REQUEST

Approximately 10.26 acres located on Shopton Road between Steve Chapman Drive and Pinecrest Drive.

The petition proposes to amend a previously approved plan to add a parcel, list additional prohibited uses, and expand to 120,000 square feet of office, warehouse, and distribution uses and outside storage.

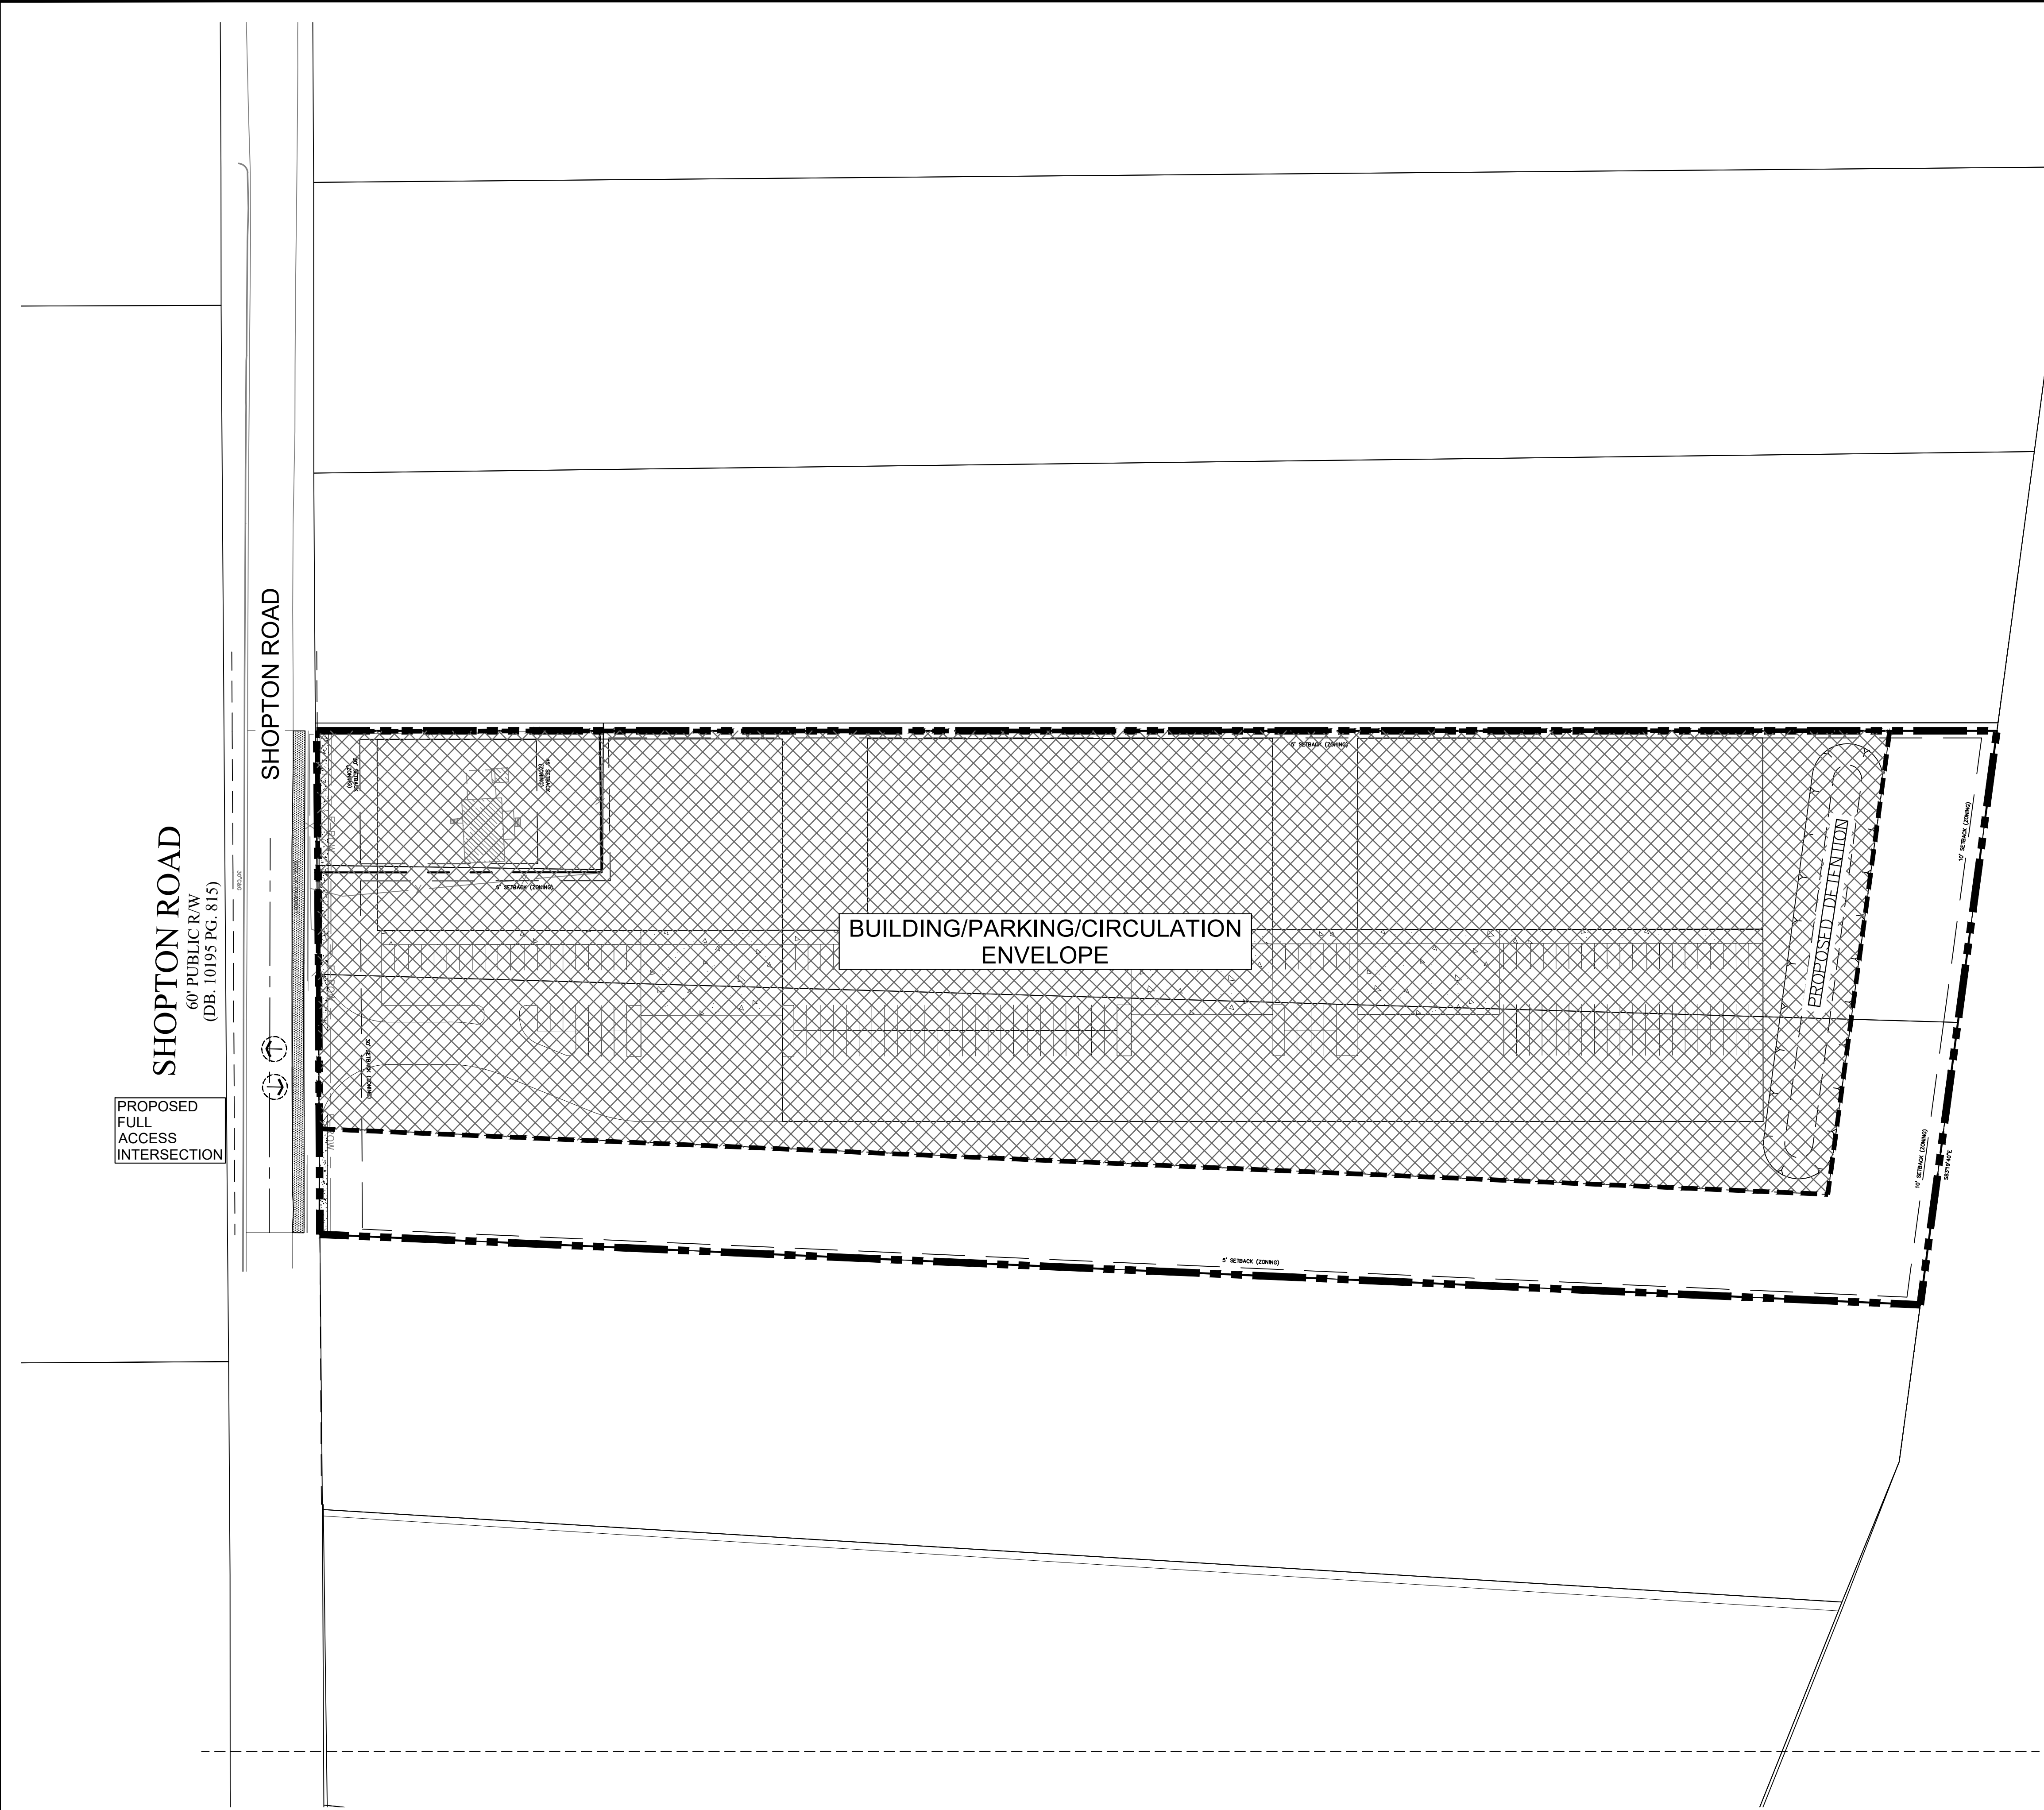
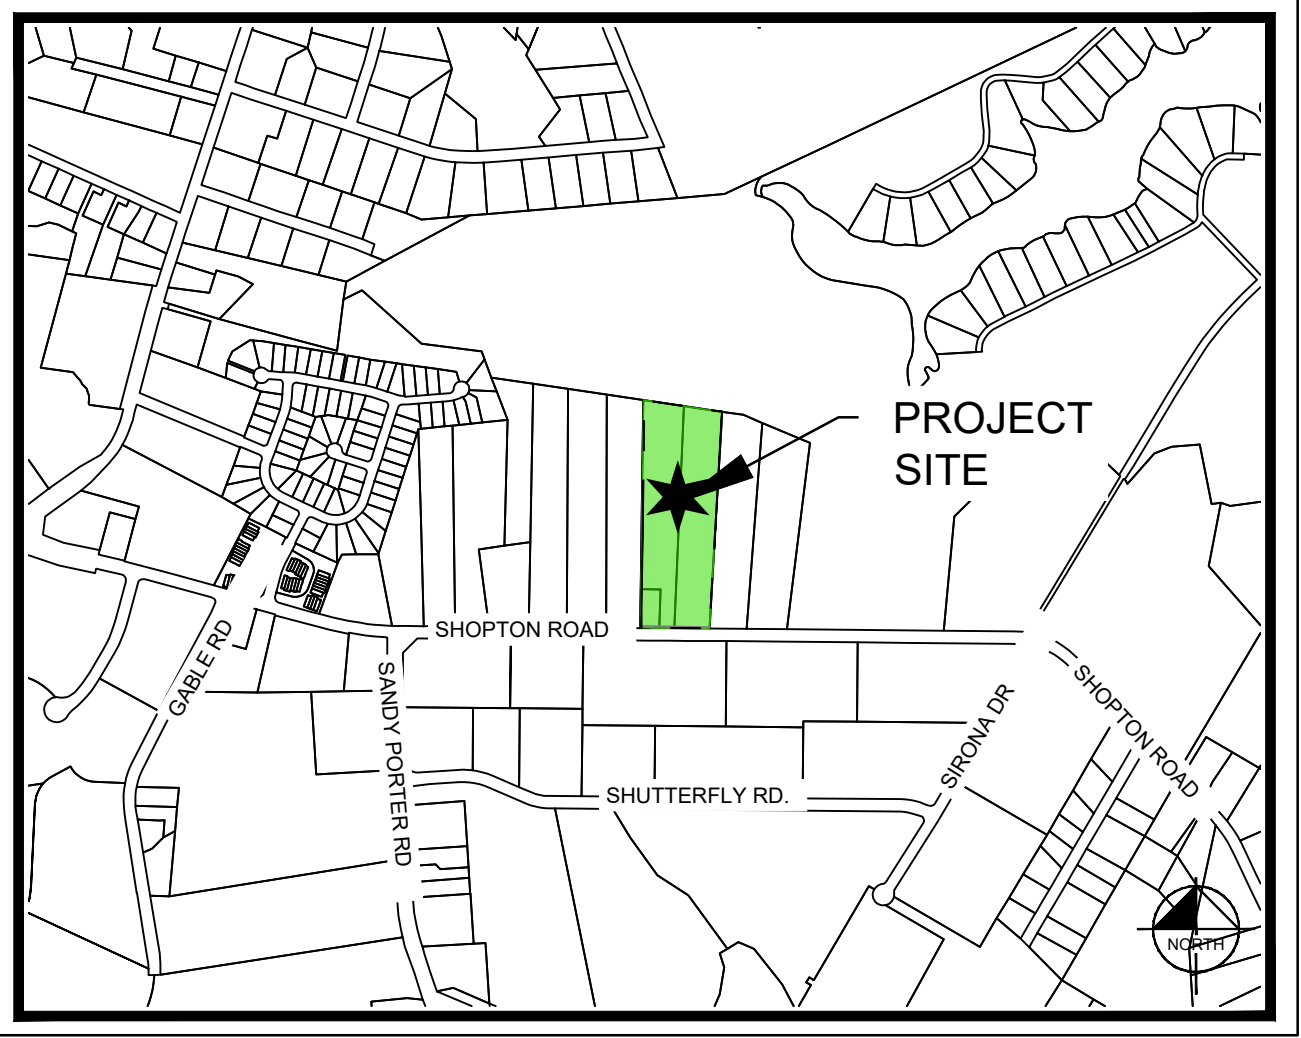
1. Label and dimension the curb and gutter at 27' from the centerline of Shopton Road on the site plan.
2. Revise site and plan and conditional notes to commit to constructing an 8' planting strip and 8' sidewalk as specified in the Charlotte Walks policy.
3. Add a conditional note that the entire sidewalk must be outside of the right of way and within a public access easement. Add a conditional note committing to construction and maintenance of the 8' sidewalk on Shopton Road.

4. Delete all items that were applicable to the previous petition but not to the current petition.
5. Illustrate on the site plan right of way at 35' from centerline and 20' setback. Remove hatching from area within the setback. No use or parking and maneuvering are permitted within the setback.
